RE: 620170624MAJ - Plot 5000 Hatfield Business Park, Hatfield, AL10 9EZ

Thank you for your consultation in relation to the above planning application for the erection of a 3 storey building for B8 (storage and distribution) (4,878m²) and B1 (office/light industrial) (1,550m²) use, together with 100 car parking spaces, 10 cycle parking spaces, boundary treatment, landscaping, lighting and access, at Hatfield Business Park, Hatfield, AL10 9EZ.

We understand this application seeks full planning permission for a major development, and we have assessed the Flood Risk Assessment & Drainage Strategy prepared by Baynham Meikle Partnership Ltd, project reference PT/12313, dated March 2017, submitted to support to this application. However the information provided to date does not provide a suitable basis for an assessment to be made of the flood risks arising from the proposed development.

Project Title	Project Engineer
HATFIELD BUSINESS PARK PLOT 5000	N.S.B.
Drawing Title	Project Engineer
PROPOSED CAR PARKING AND DRAINAGE STRATEGY PLAN	N.S.B.
Drawn by K.M.	Checked by P.T.
Date FEB 2017	Scale 1:500
Project No 12313	Drawing No 106
Rev B

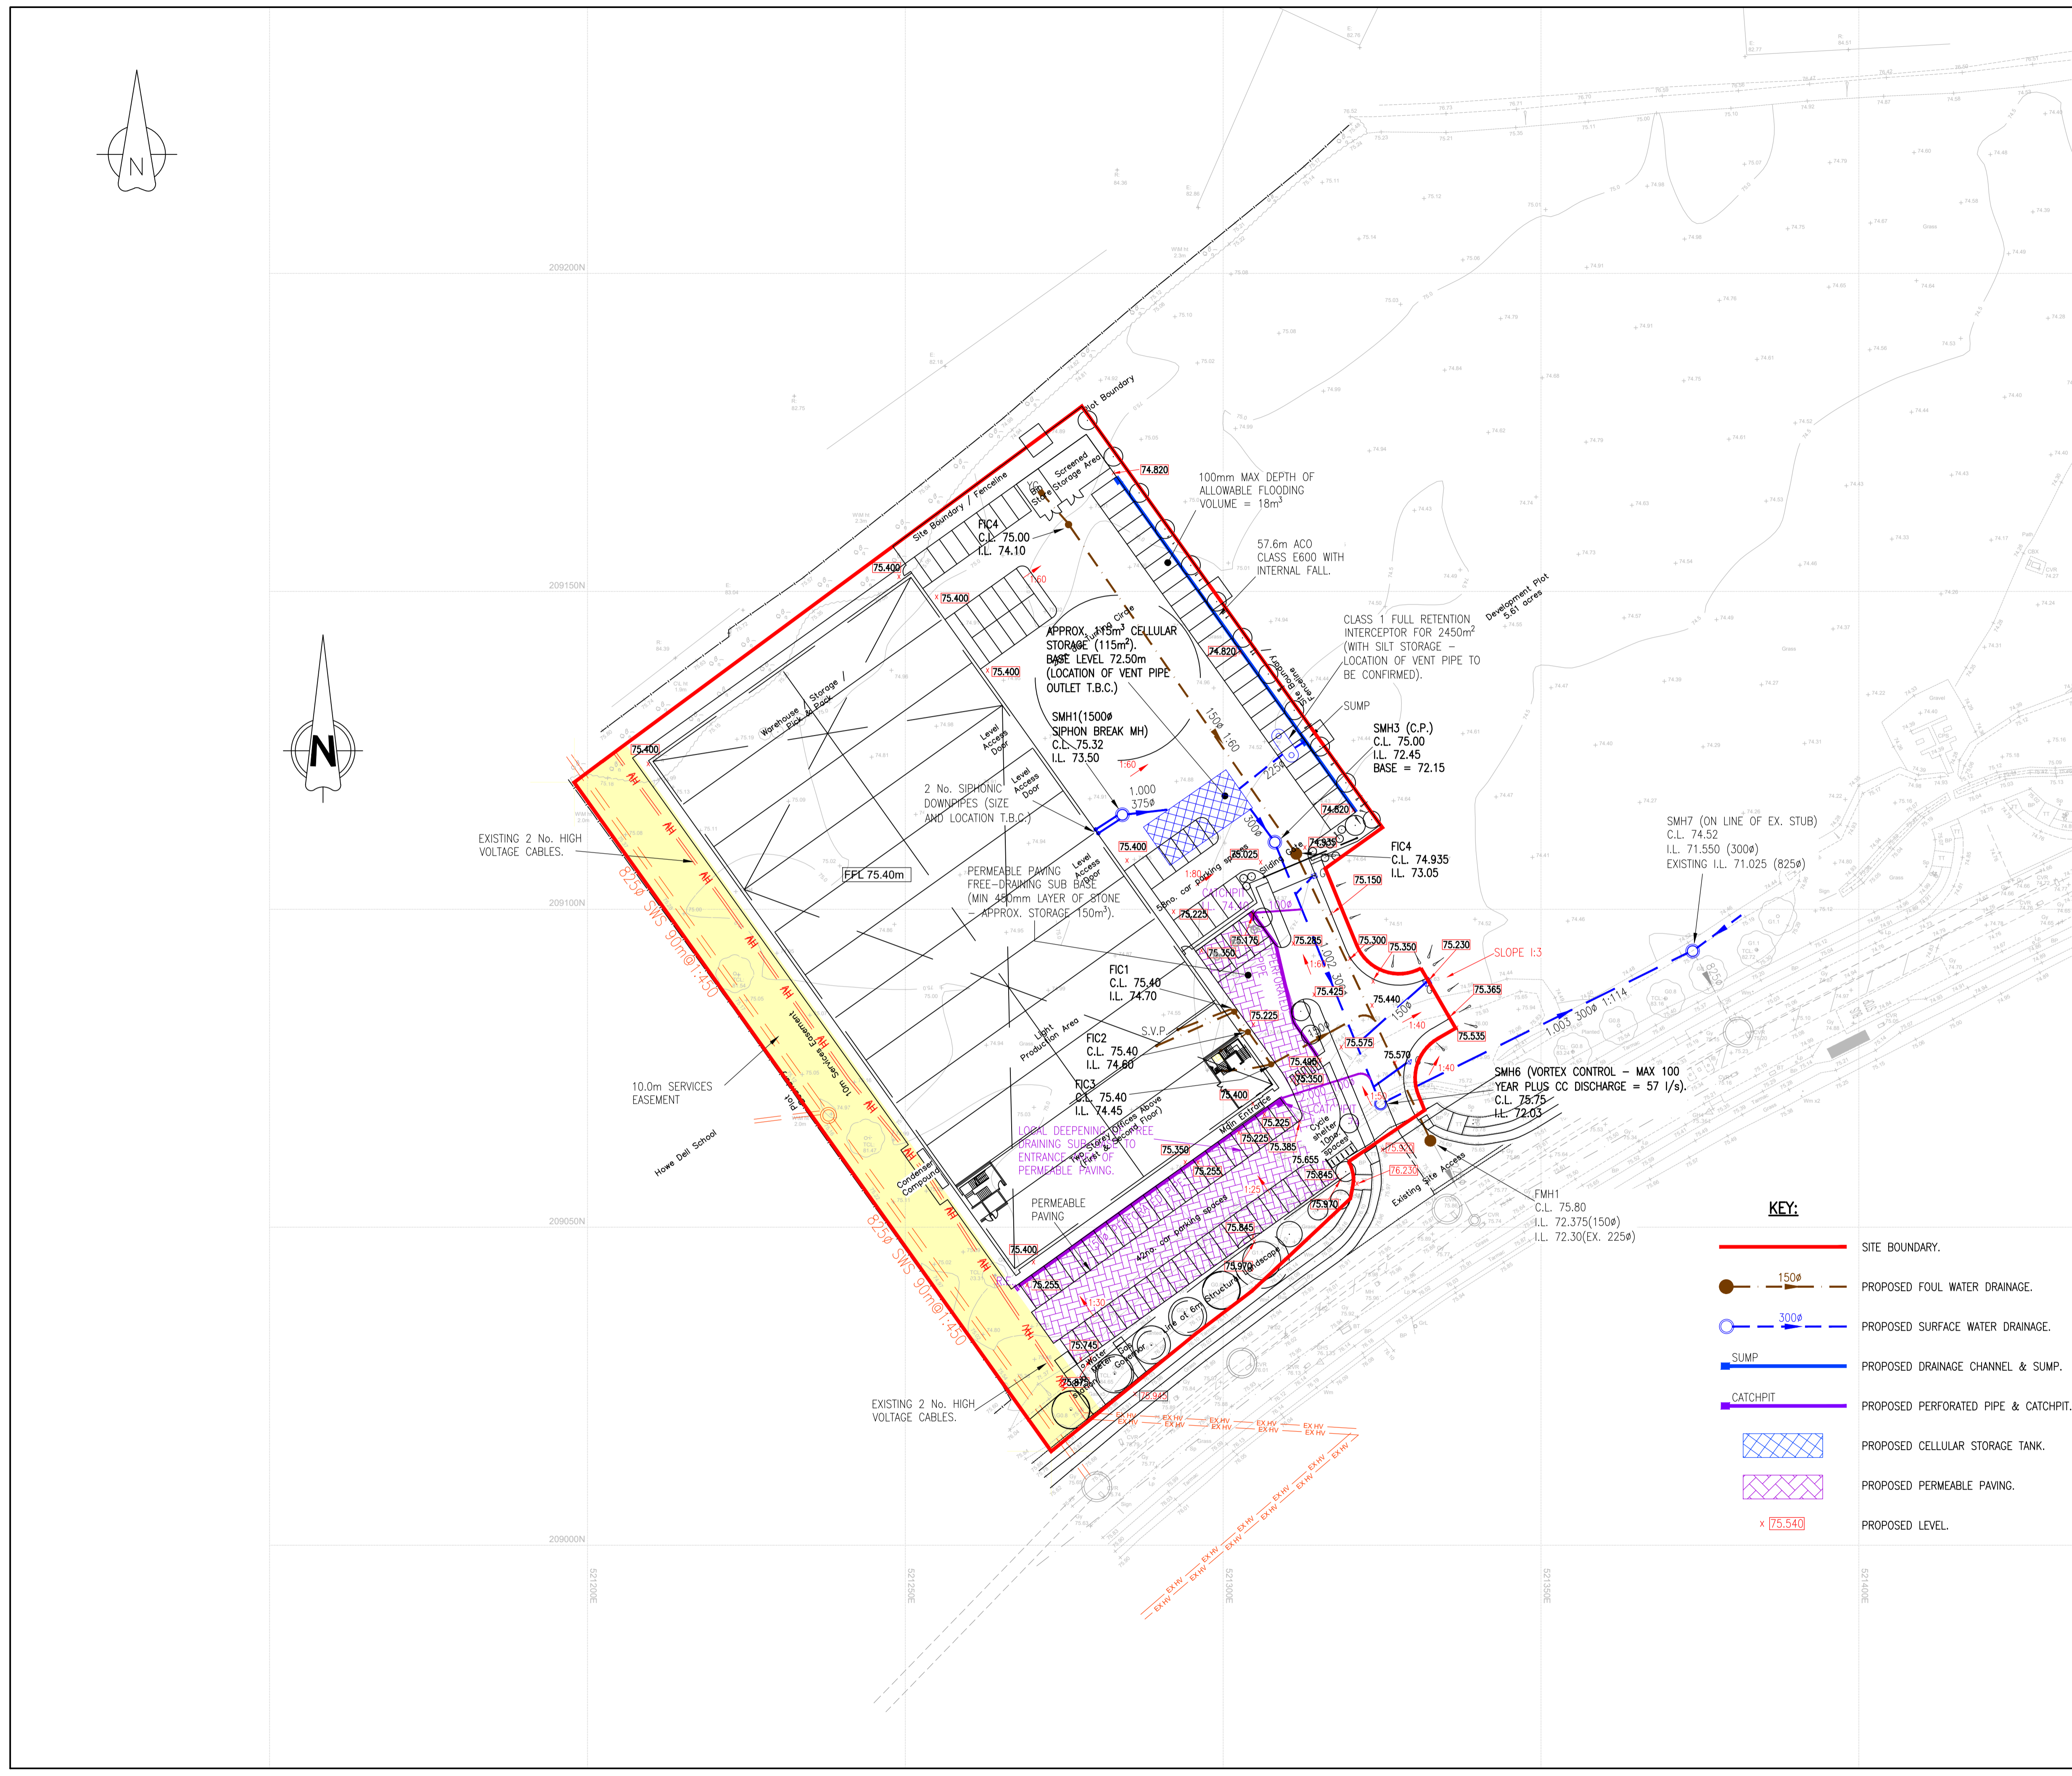
- 3&4 We acknowledge that the applicant has provided the drainage layout. However, if there will be informal flooding within the site, these areas need to be identified on a development layout plan, showing the extent and depth of the flooding and under what rainfall event the flooding will occur. No flooding should occur at and below the 1 in 30 year rainfall event. It should be demonstrated that any flooding above this can be managed within the site without increasing flood risk to the proposed properties and the surrounding area. Both the 1 in 100 year and the 1 in 100 year plus climate change extents, depths and volumes should be established. Routes of exceedance will also need to be assessed and identified for rainfall events that exceed the 1 in 100 year plus climate change event.
